# OXFORDSHIRE COUNTY COUNCIL'S RESPONSE TO CONSULTATION ON THE FOLLOWING DEVELOPMENT PROPOSAL

**Application no:** 22/03063/F

**Proposal:** Erection of 123 dwellings with access from Camp Road, provision of public open space and associated infrastructure.

**Location:** Land East Of Larsen Road, Heyford Park

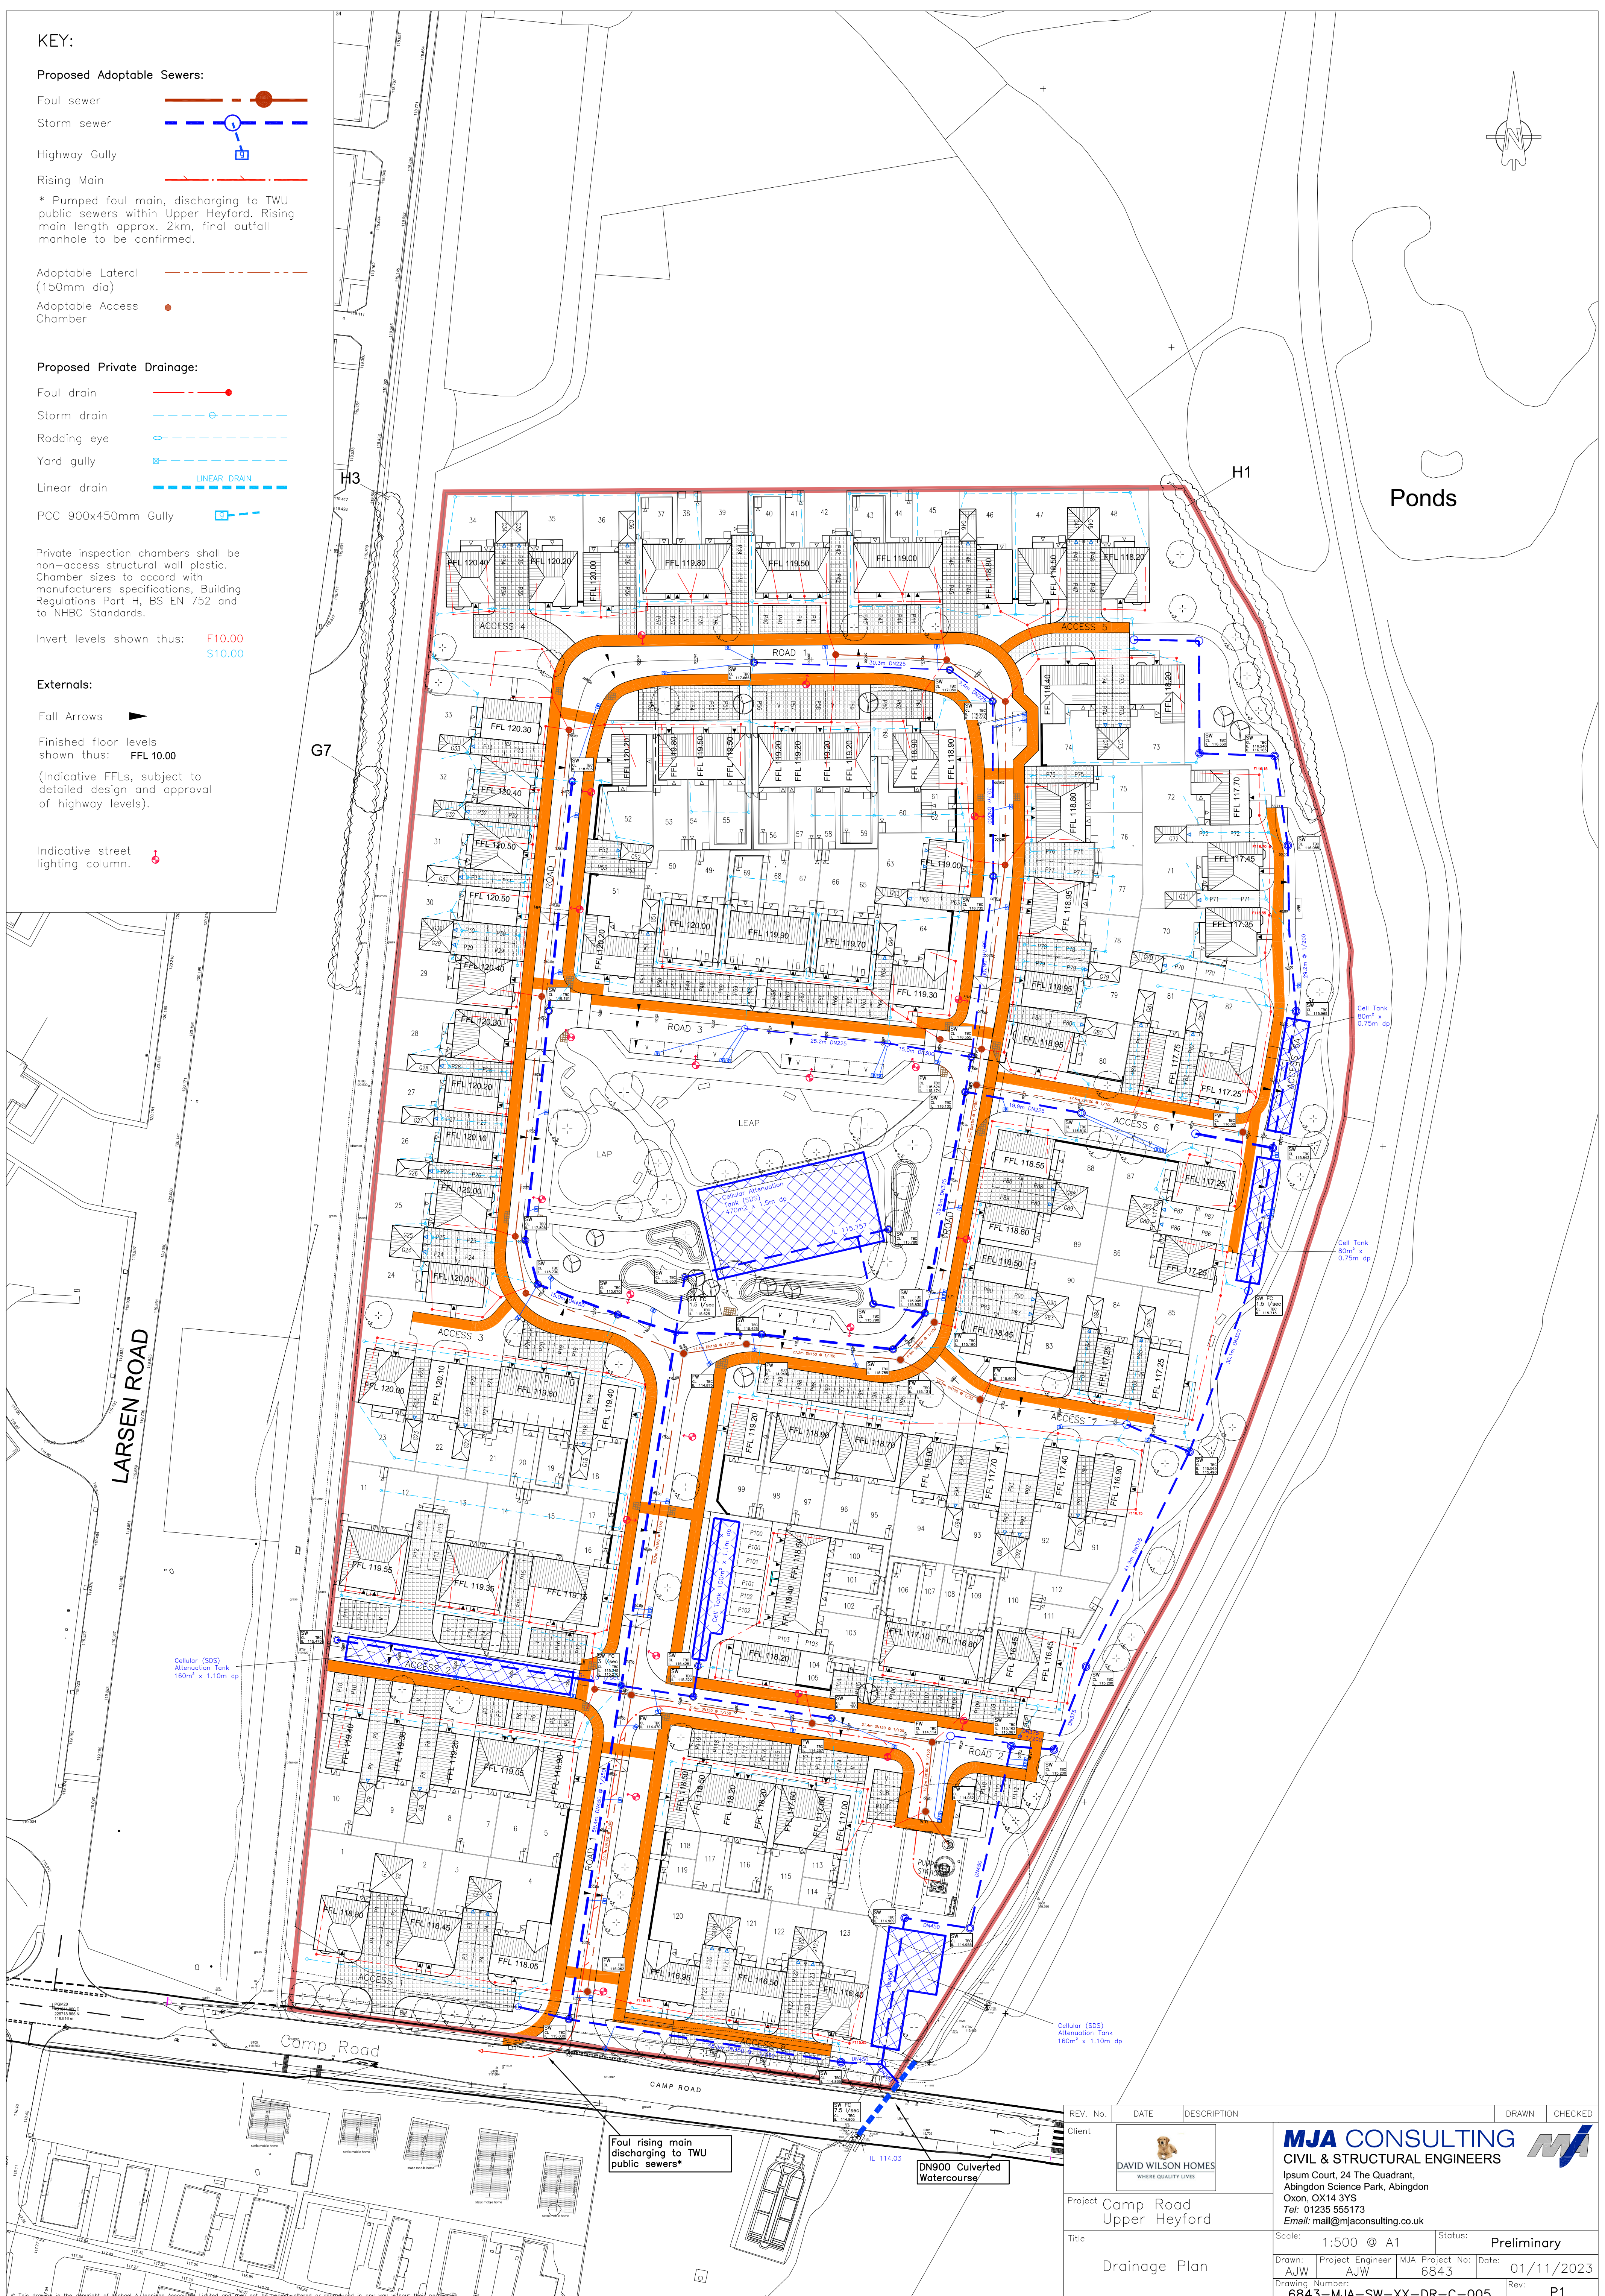
Drainage strategy drawing (DRG NO.22-192-100, Rev C) provided and does not address the comments below. Drainage connections around the plots from and to the permeable needs to be shown.

All the drainage infrastructure around the private plots needs to be shown. Provide invert and cover levels of all SuDS/drainage infrastructure. Include pipe gradients and pipe numbering which should read in line with the calculations.

Surface water from the development can't be discharged into a highway system, highways systems will only take run off from highways only. Provide correspondence from the highway authority.
